Our Ref: P/171/21/DOC

Approval of details reserved by condition imposed under ref W/4001476 (P/58/19/PL) relating to Condition Nos 10 - proposed location of one fire hydrant or stored water supply, 12 - soft & hard landscaping, 14 - materials & finishes and 15 - boundary treatments.

Rear of Inglenook Hotel 253-255 Pagham Road Pagham PO21 3QB

INGLENOOK PROPOSED FIRE MAIN SKETCH

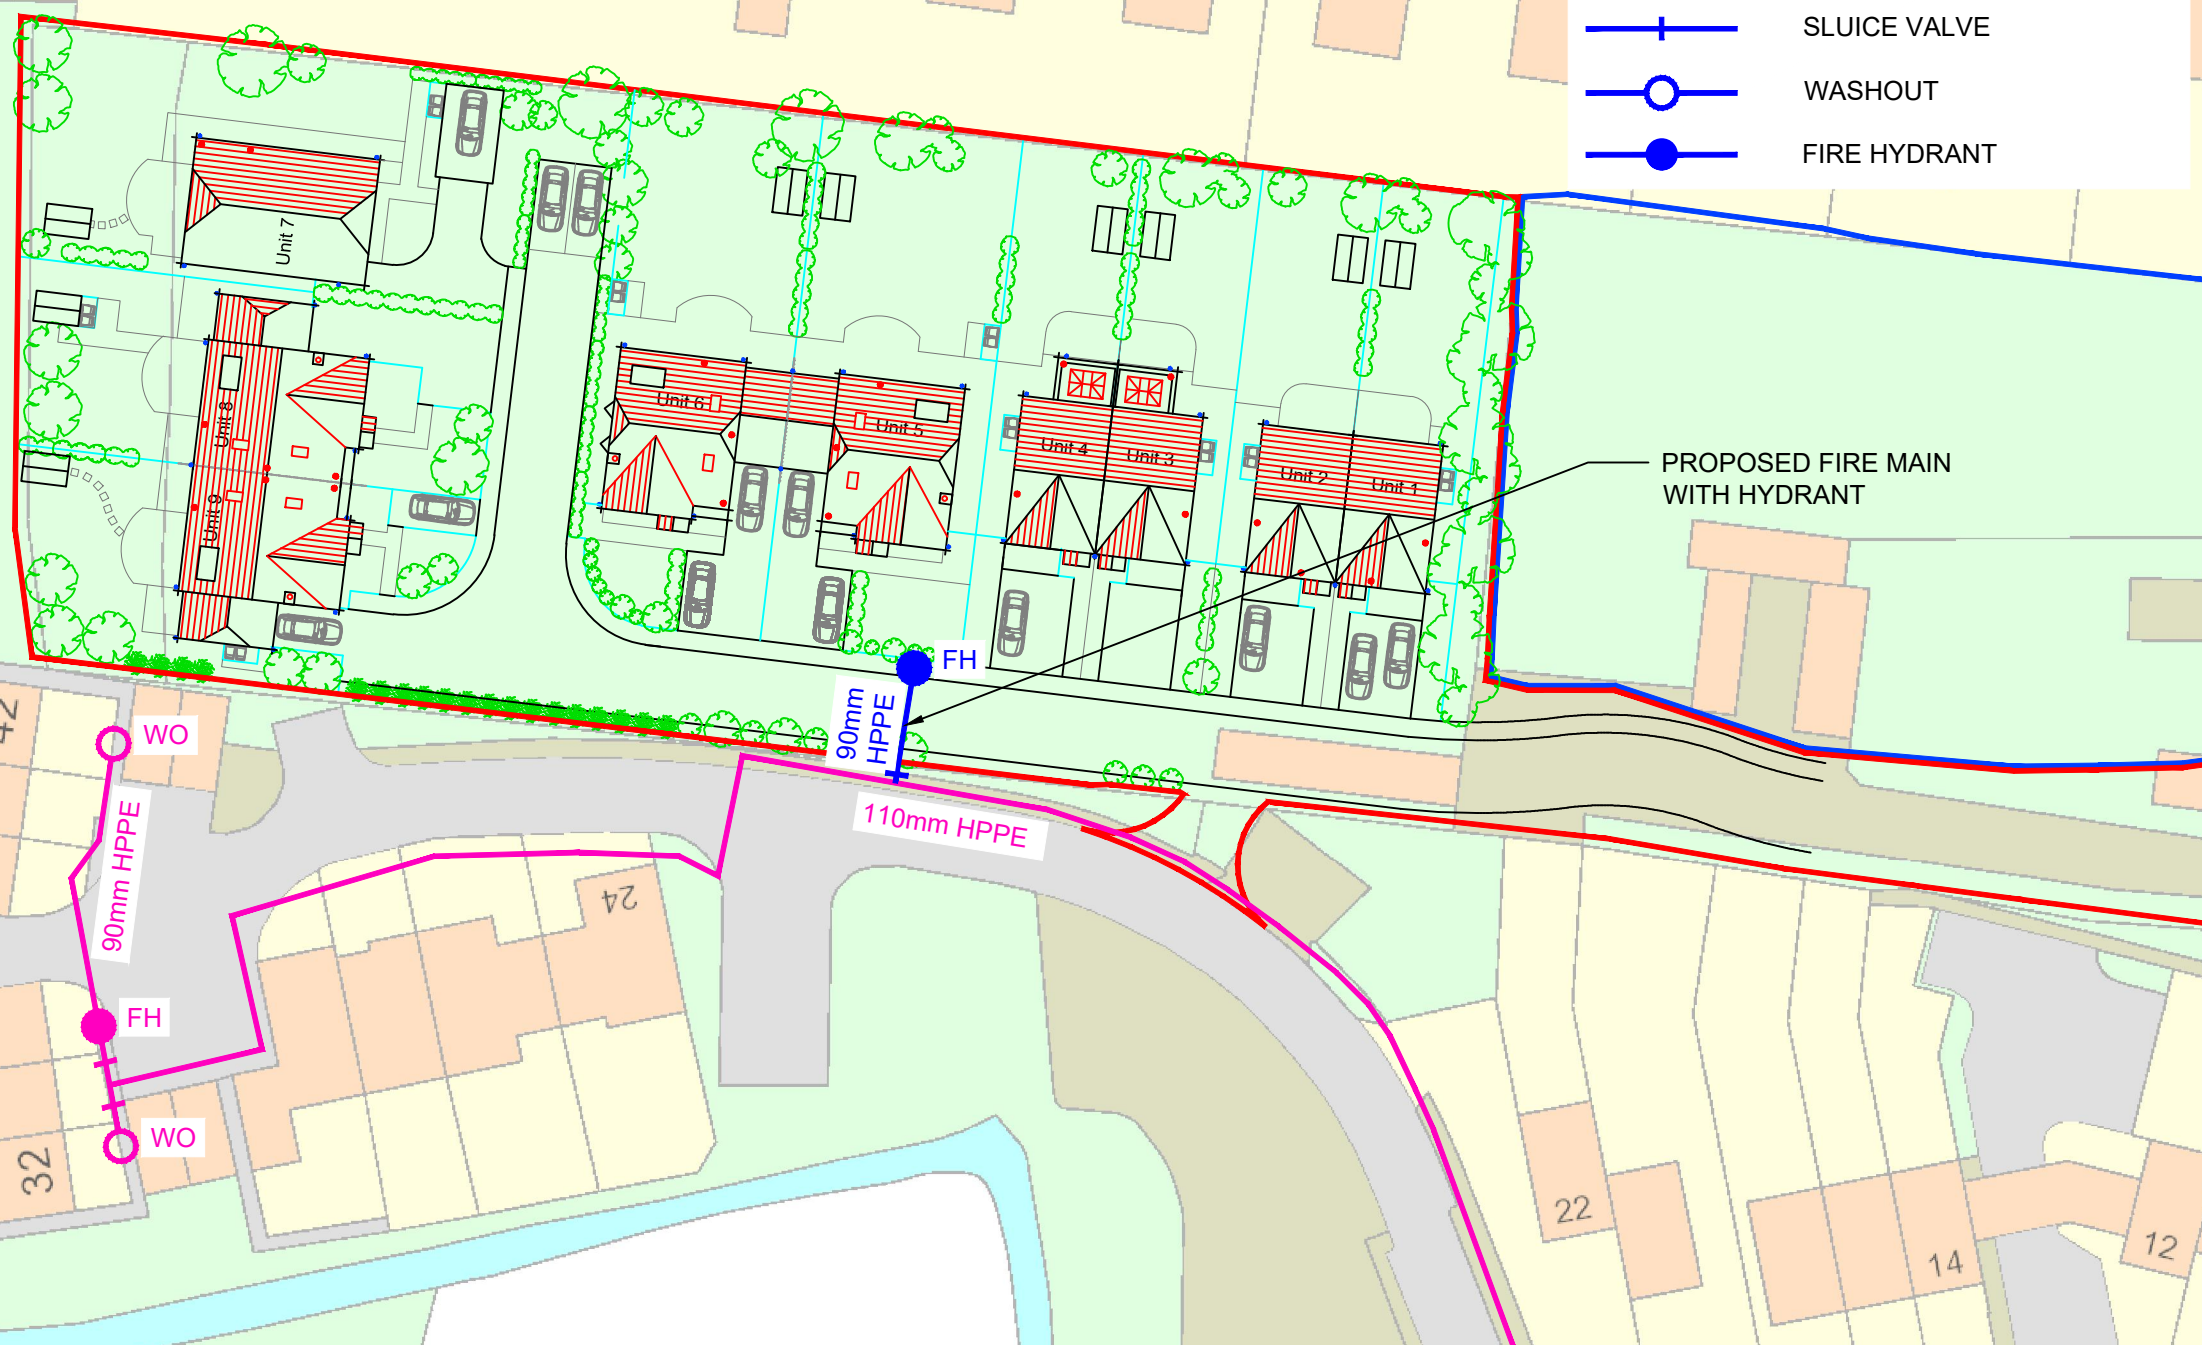
The condition requires details of the location of a fire hydrant to serve the new housing development. You have provided drawing SK/01 Rev A "Proposed Fire Main Sketch" which shows the location of a Fire Hydrant within the site area connecting to the water main in the adjacent Spinnaker View development.

WSCC Fire & Rescue advise that the details are acceptable subject to it being provided prior to occupation, tested, the location being identified with an H plate, cover sprayed yellow and also plotted in the WSCC mapping system. The condition is therefore hereby discharged insofar as the submission

However, should it not be possible to agree the connection to the water main in Spinnaker View due to land ownership issues then you will need to reapply to discharge this using an alternative water source.
